Planning ref: Planning Application No. BN/97/25/PL

Location of application: Land off Church Lane Barnham

Details of application: Change of use of land from agricultural use to residential use, creating 4 No permanent private gypsy plots with associated parking, landscaping and facilities.

As Proposed Site Plan

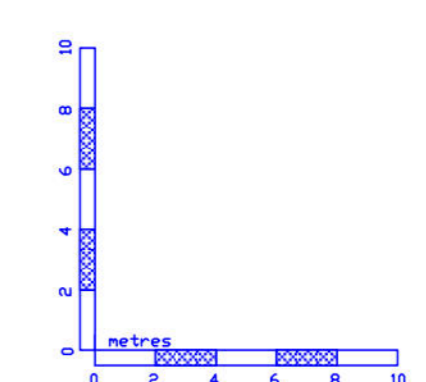
- Further planting of native hedging is planned. The Site Plan suggests that the gap between the new hedgerows is greater than that of the existing hedge line to the east, but is not explicitly defined. This should be set out to ensure the available width of the footpath meets the requirements set out by the Highway Authority.

In the event that the Planning Authority are minded to approve the application, then a planning condition should be set to ensure that the planting and boundary fencing alongside the footpath meet the requirements set by the Highways Authority, who should also be consulted on the matter [REDACTED]
